Application Ref:	3/2026/0485	 Ribble Valley Borough Council www.ribblevalley.gov.uk
Date Inspected:	18/4/24	
Officer:	BT	
DELEGATED ITEM FILE REPORT:		REFUSAL

Application Description:	Non material amendment to application 3/2024/0530 involving elevation changes to windows, doors and the main entrance roof and the main entrance lobby re-positioned.
Site Address/Location:	Barn at Cockshotts Farm, Stubbins Lane, Sabden, BB7 9EH.

DRAWING TITLE			
PROPOSED NORTH & SOUTH ELEVATIONS			
DRAWN	ERA	REVISIONS	DRAWING No.
DATE	20/04/2026	P1P2	AR/P01
SCALE	1:100/1:50/1:20 @ A1

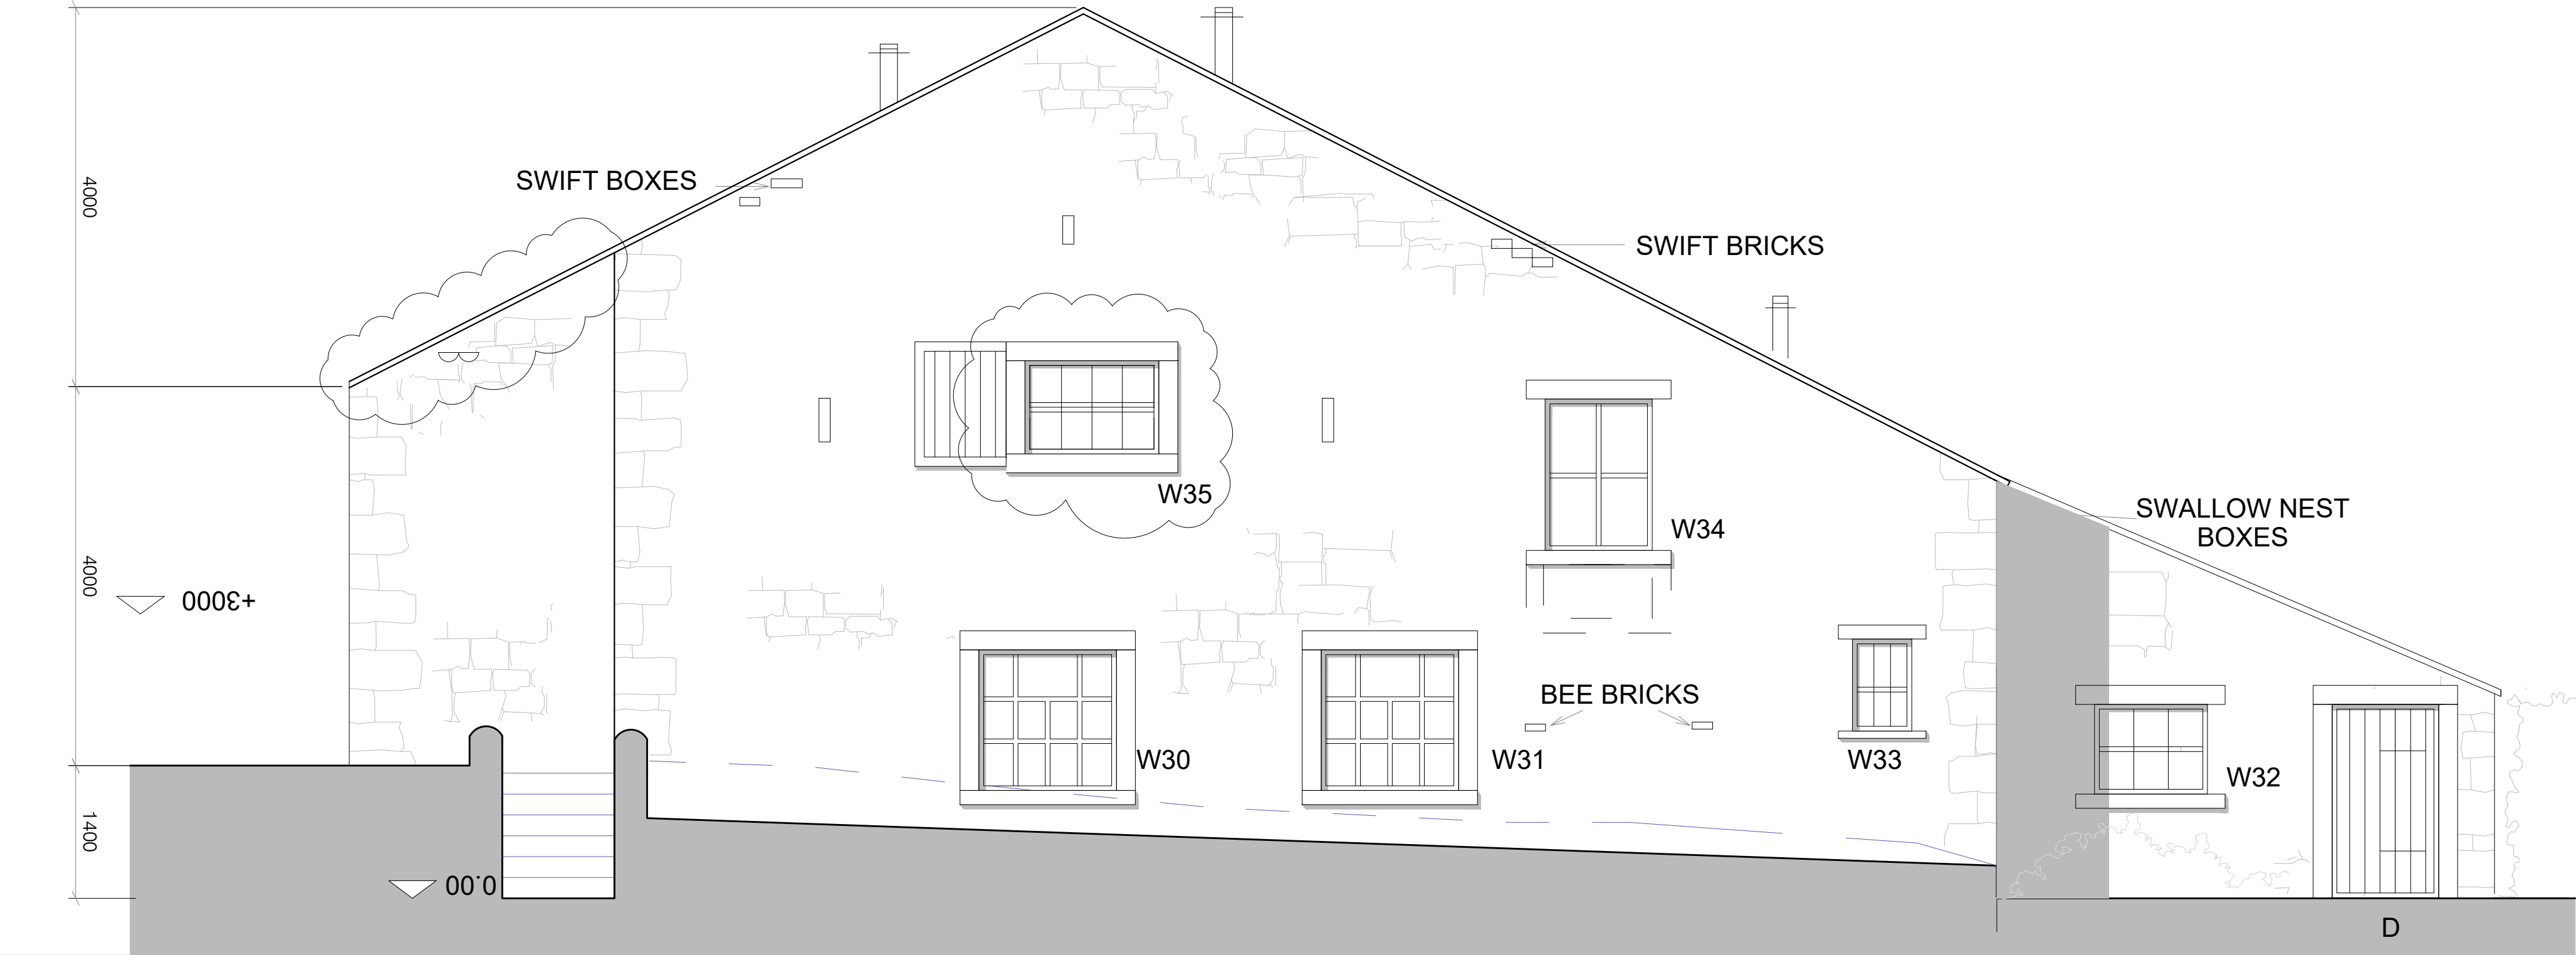
fenestration pertaining to application 3/2024/0530 resulting in the barn’s randomised sequence of openings and agricultural character being retained. The existing first floor windows are predominantly square and the approved scheme reflected that. In contrast, the proposed amendments to the approved scheme of fenestration would involve the introduction of numerous window openings with a rectangular emphasis as outlined above which, when read in conjunction with the barn’s rectangular openings at ground floor, would subsequently disrupt the building’s randomised sequence of openings through introducing additional glazing and a noticeably regimented pattern of fenestration and solid to void ratio which in turn would give the barn building an overtly domestic appearance (particularly on the North-eastern elevation of the barn building). In addition, the patio doors proposed for the South-western elevation of the barn building would be more prominent than the approved single door opening with respect to their width to the extent that these would compete with the barn’s South-western cart entry feature. Furthermore, the introduction of a roof feature over the barn’s North-eastern cart entry walls would result in a noticeable visual change to the barn’s existing (and as approved) North-eastern cart entry and roof profile, with no justification having been provided for the introduction of this feature.

Taking account of the above, it is considered that the cumulative visual impacts of the amendments sought would result in a fundamental change to the design and external appearance of the development originally approved, with the amendments proposed amounting to a development that would be materially different in terms of design and external appearance to that of the original consent.
